Application for a Non-Material Amendment Following a Grant of Planning Permission

Land North of Beechbank

Proposed demolition of vehicle workshop and erection of 1 dwelling

2023/0161

SOUTH ELEVATION

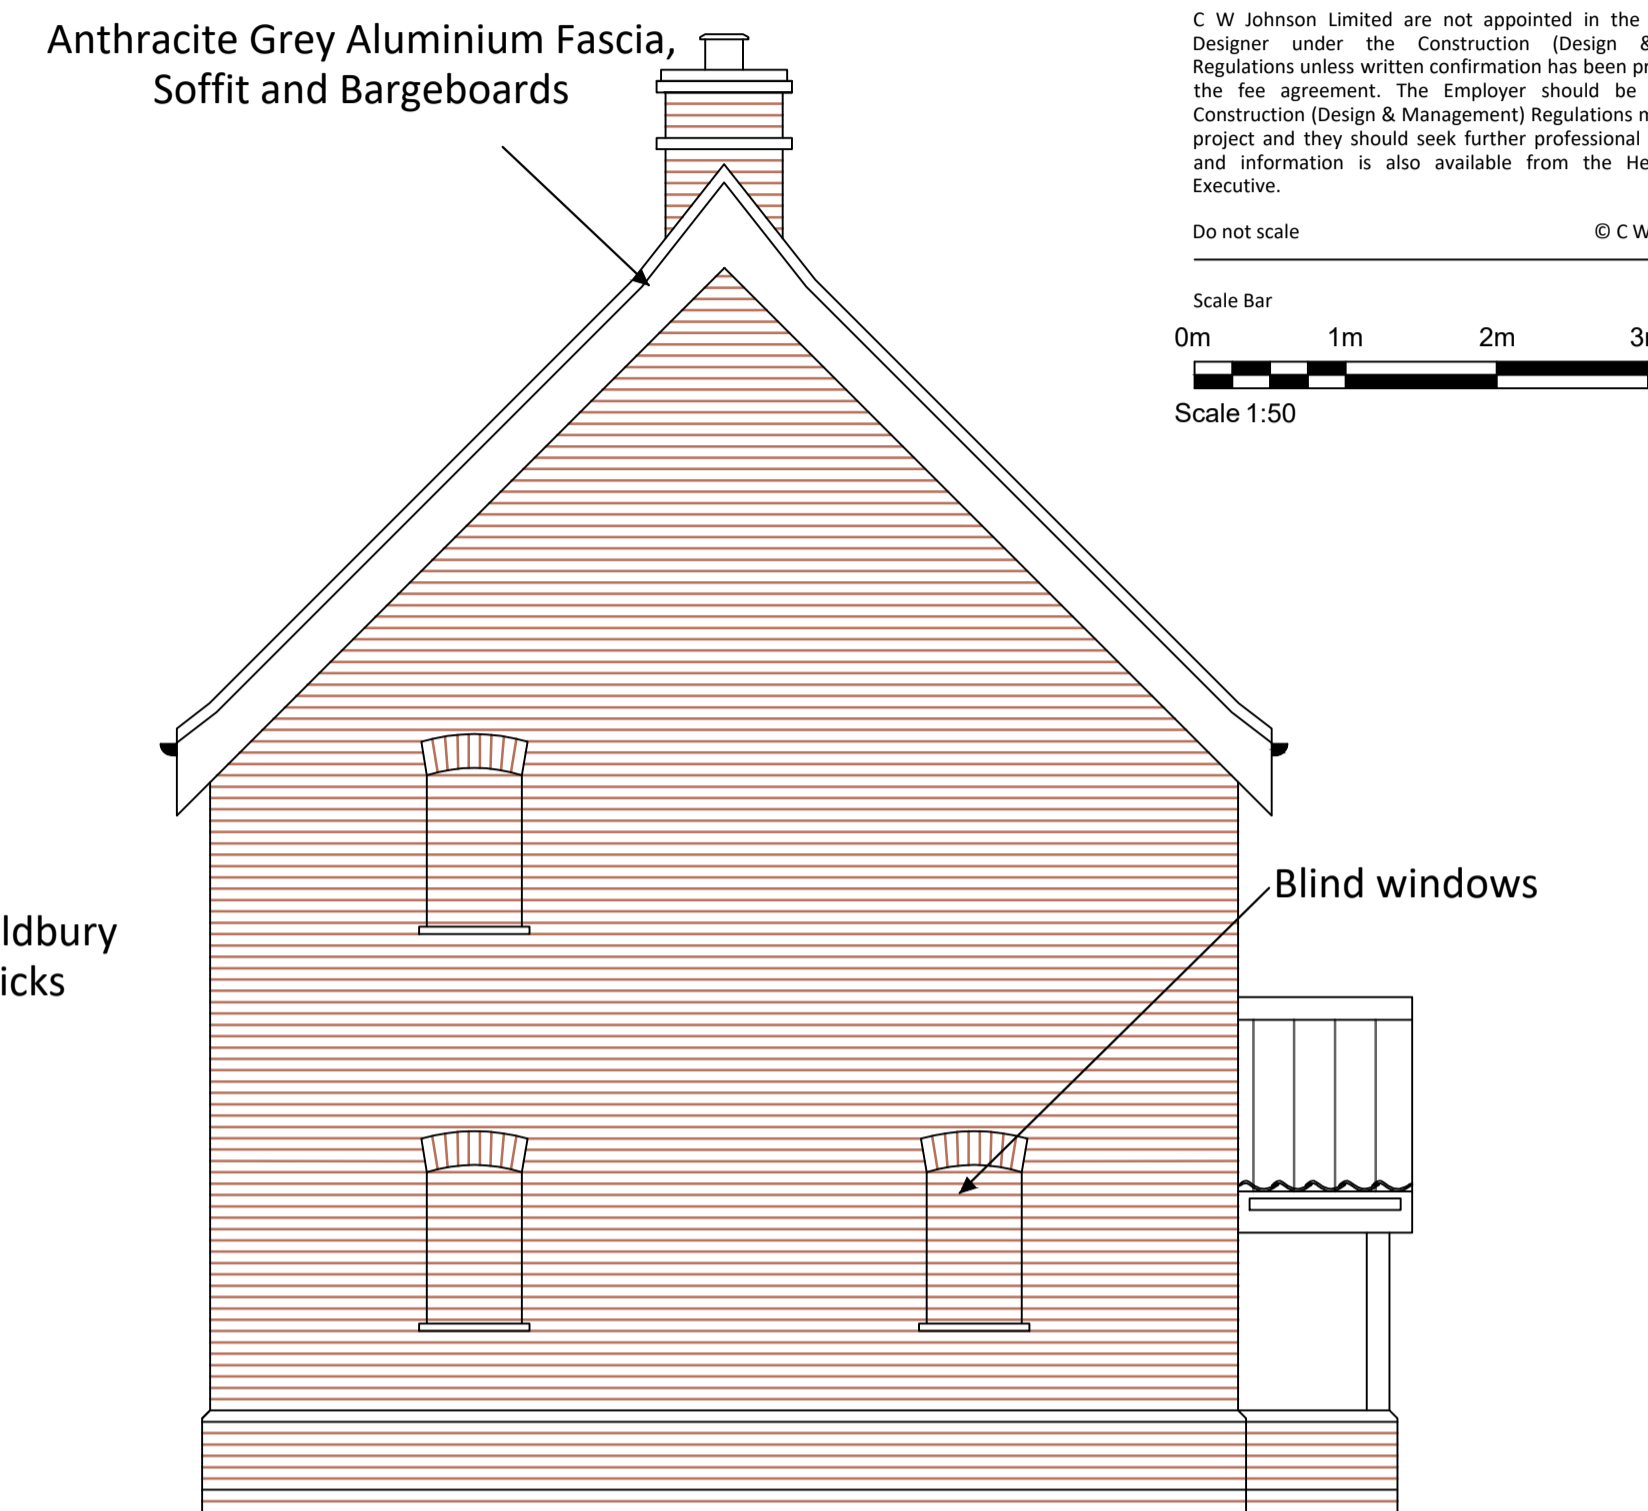
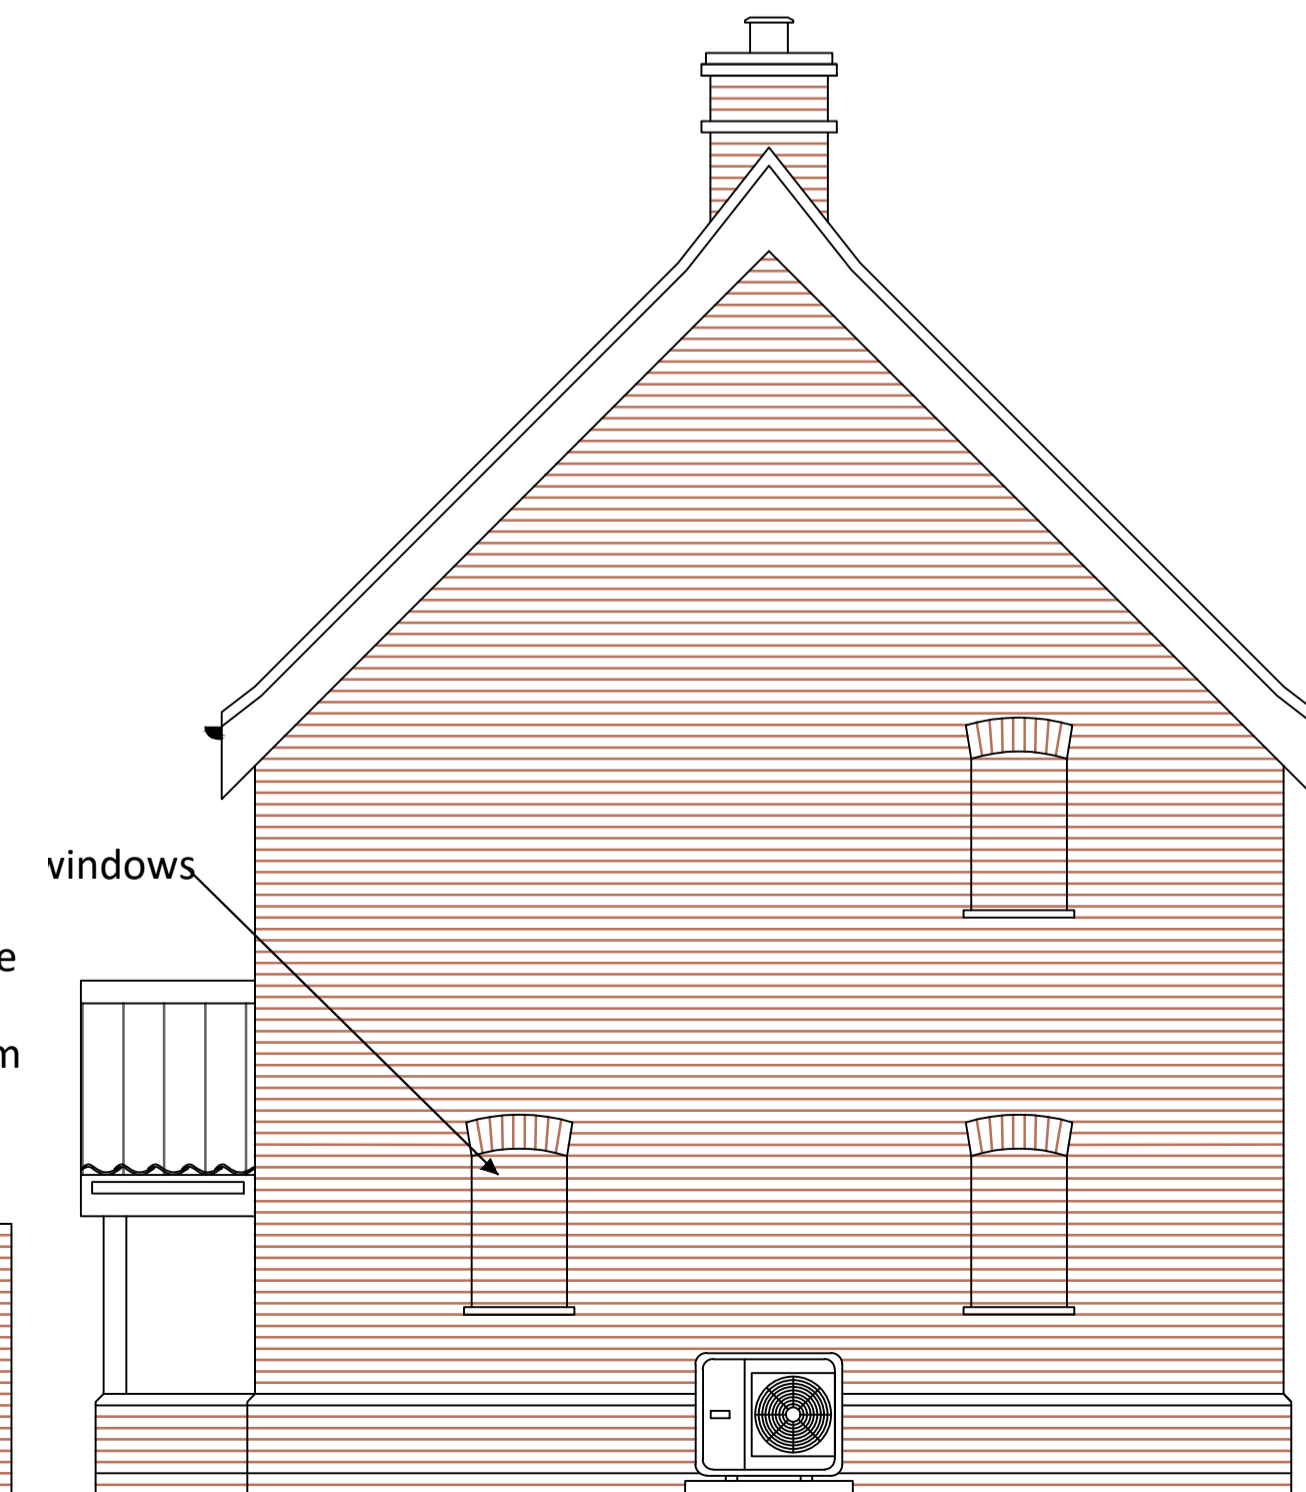
Removal of windows to south and north elevations and replacing with blind windows finished in matching brickwork to principle elevation. Reduction in width of 2 No French doors to west elevation from 1800mm to 1500mm. Changes requires to ensure compliance with Part O of the Building Regulations.
